Department of Transportation

RE: Waterbury Filings Nos.1 and 2 PUD PP - PUDSP215

The Master Development Drainage Plan & Preliminary Drainage Report for Waterbury Filings No. 1 & 2 dated March 2022 and the Grading, Erosion & Sediment Control Plan for Waterbury Filings No. 1 & 2 dated July 20, 2022 have been reviewed by a CDOT Hydraulics Engineer. Their comments follow:

EAST CONCRETE FOREBAY/MICROPOOL DETAILS
SCALE: 1"=10'

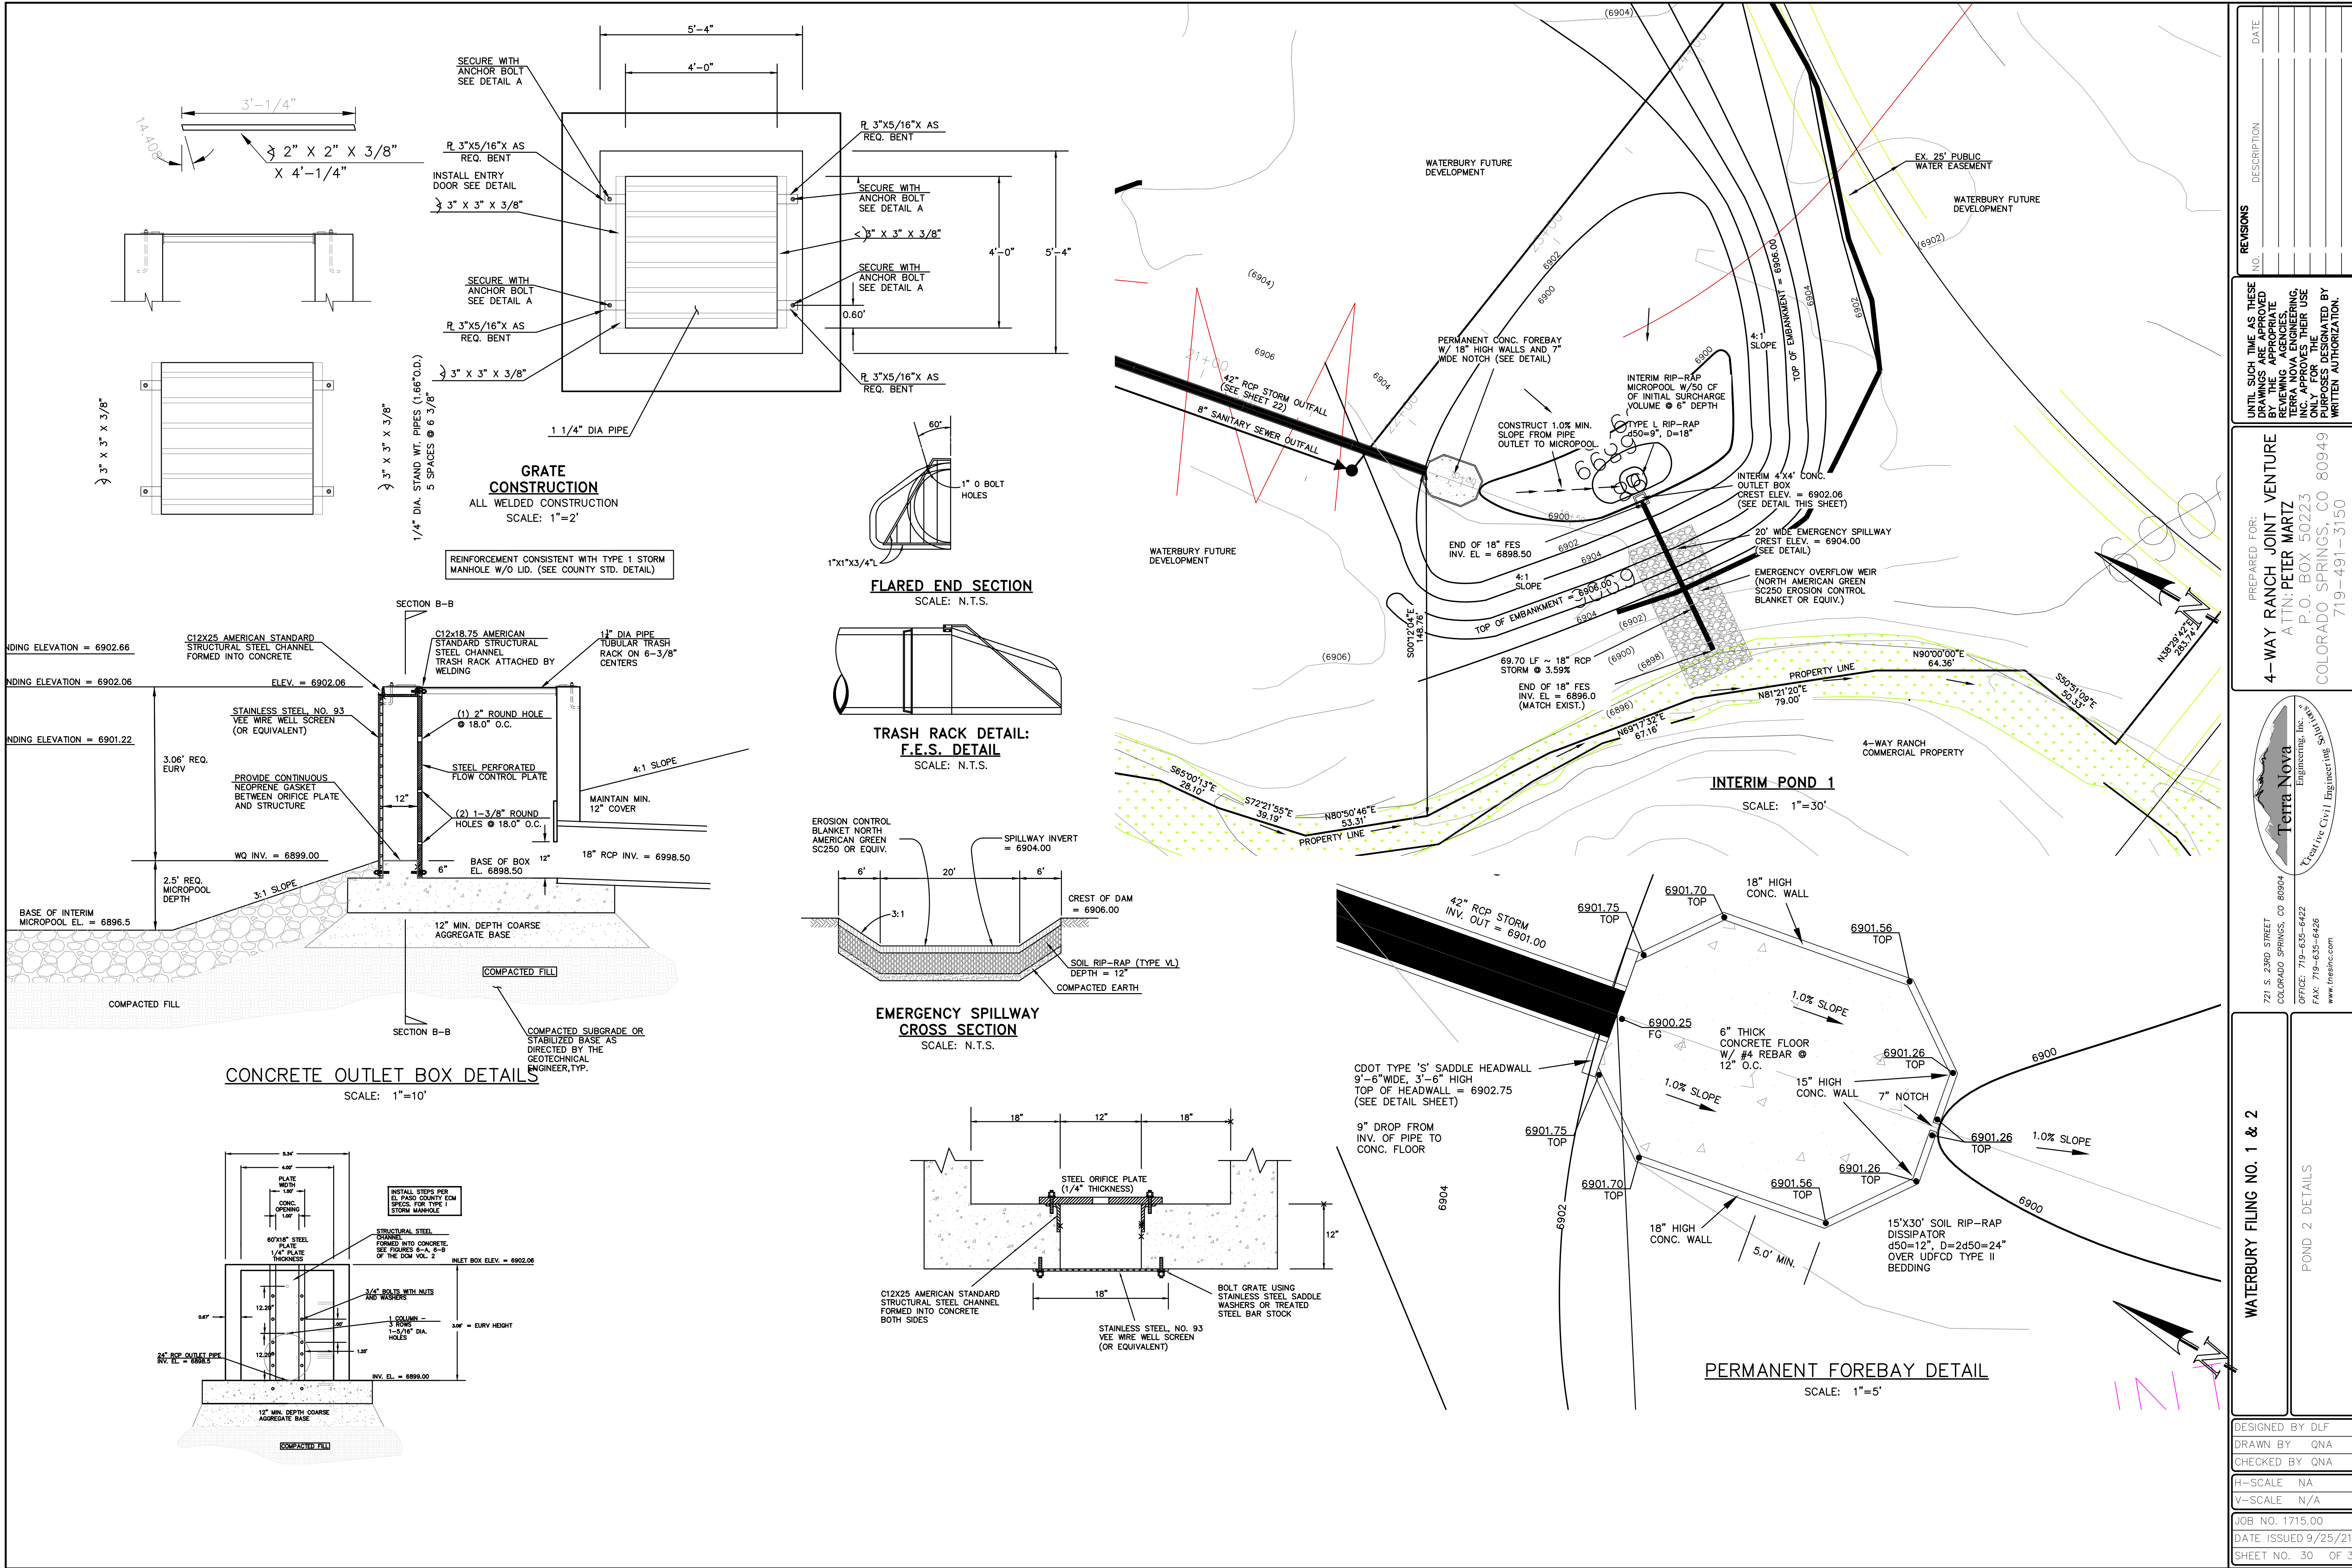
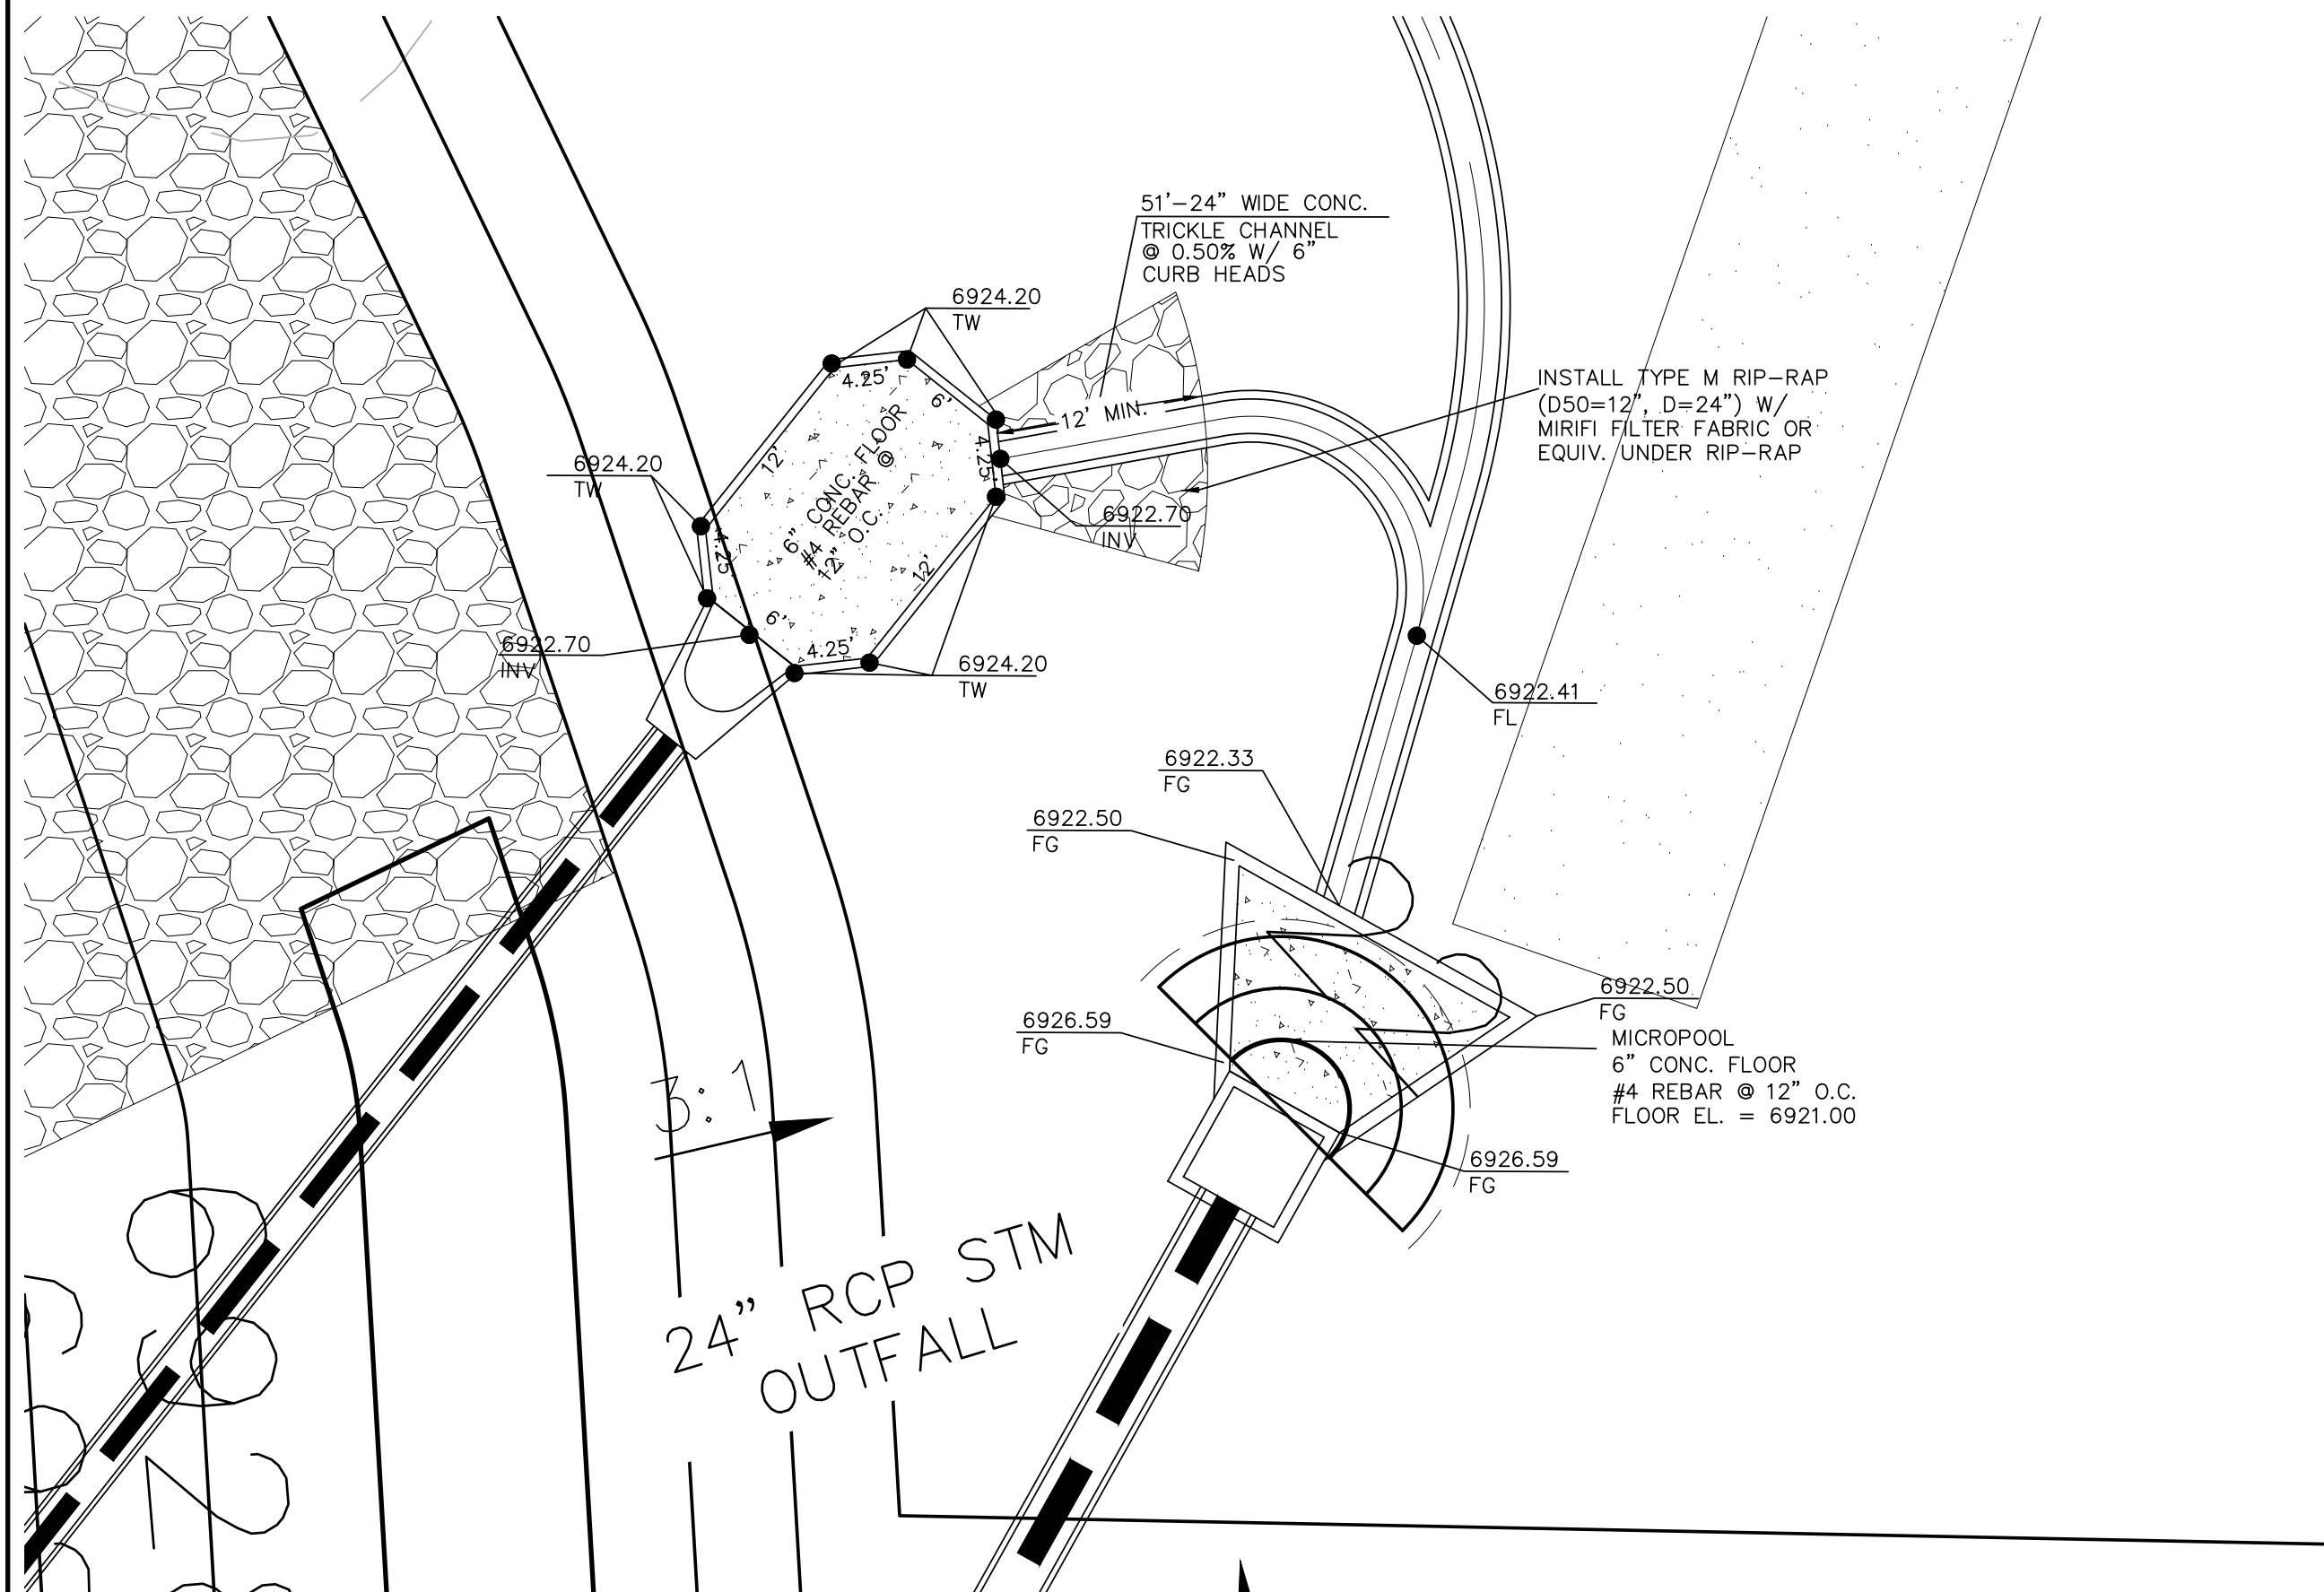
- Note: The construction set was not resubmitted in this submittal. The construction set from the previous submittal (October 2021) was reviewed and compared to the inputs in the H&H calculations.
- Basin forebays are located concerningly close to the outlets. Consider revising the layout of the detention basins to prevent short-circuiting the basin. Refer to the CDOT Drainage Criteria Manual (DDM) Chapters 12 and 16 for further guidance.

- Pond 3 ratio of peak outflow to predevelopment Q is greater than 1.0 for the 10-year event. (Page 187 of the drainage report)
- There are duplicate items in the appendix (drainage maps and HECRAS profiles).
